10 April 2017

RMS Ref: SYD15/01555/03 (A16908507)
Council Ref: SSD 7417

EIS - MIXED USE REDEVELOPMENT PROJECT
UNIVERSITY OF SYDNEY, DARLINGTON CAMPUS (SSD 7417)

Figure 5.3: Pedestrian Island Expansion

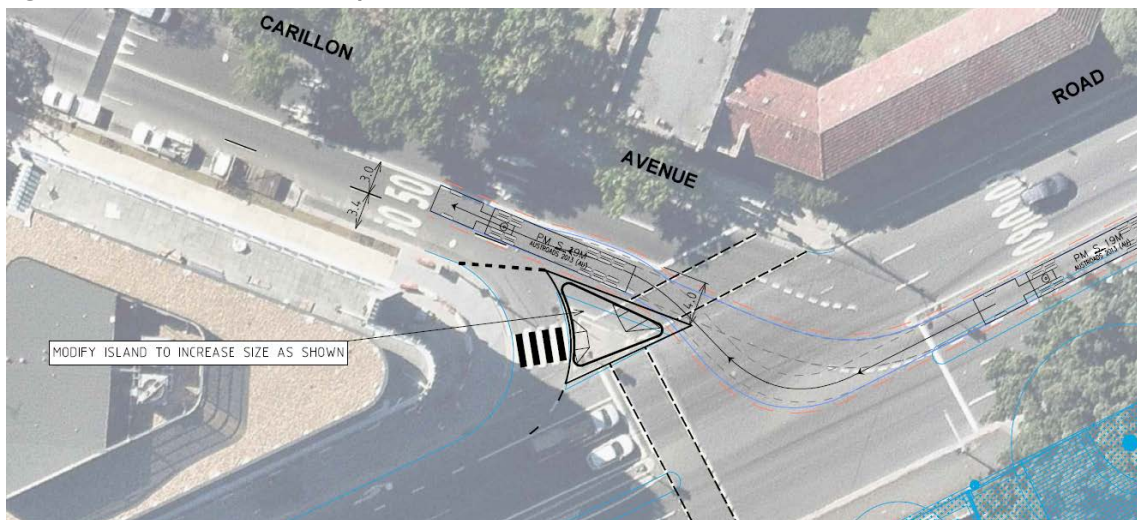
1. A Construction Traffic Management detailing construction vehicle routes, number of trucks, hours of operation, access arrangements and traffic control should be submitted to Council and Roads and Maritime prior to the issue of a Construction Certificate.
2. The application proposes modification to the north-western leg of the pedestrian island at the City Road/Carillon Avenue signalised intersection to accommodate for the volume of pedestrians.

Therefore, any modification to the signalised City Road/Carillon Avenue intersection requires the Traffic Control Signal (TCS) plan to be updated to reflect the proposed modification to the north-western leg of the pedestrian island.
